Tel: 01903 737756
Email: planning@arun.gov.uk
www.arun.gov.uk/planning
Please ask for: Mrs D Johnson
Email: daun.johnson@arun.gov.uk
Telephone: 01903 737762
Our Ref: A/16/26/CLP
Your Ref:
Date: 6th February 2026

Lawful Development Certificate for a Proposed Use or Development

Development: Lawful development certificate for a proposed hip to gable with box dormer to rear elevation, roof windows to north roof slope.
Location: 31 Palmer Road Angmering BN16 4LJ

Drawing Title: As Existing - Elevations

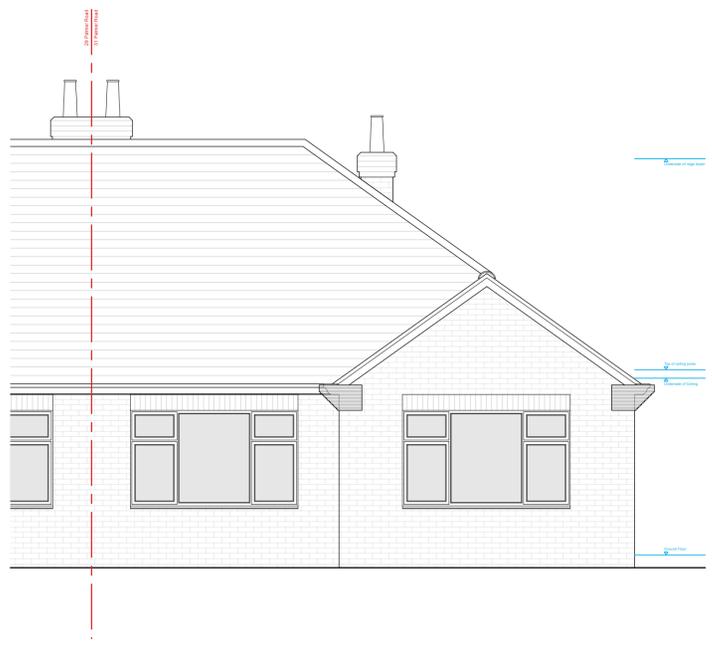
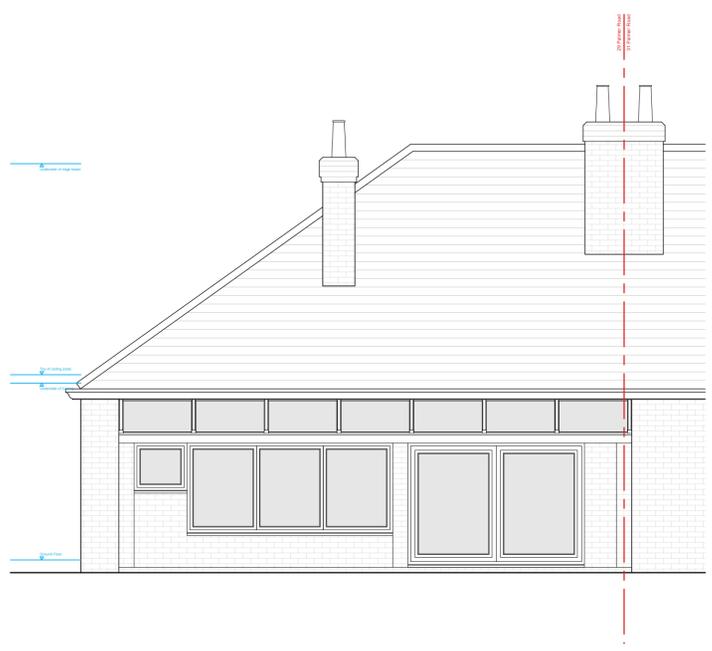
The existing and proposed east elevations have been labelled incorrectly. Please amend accordingly.
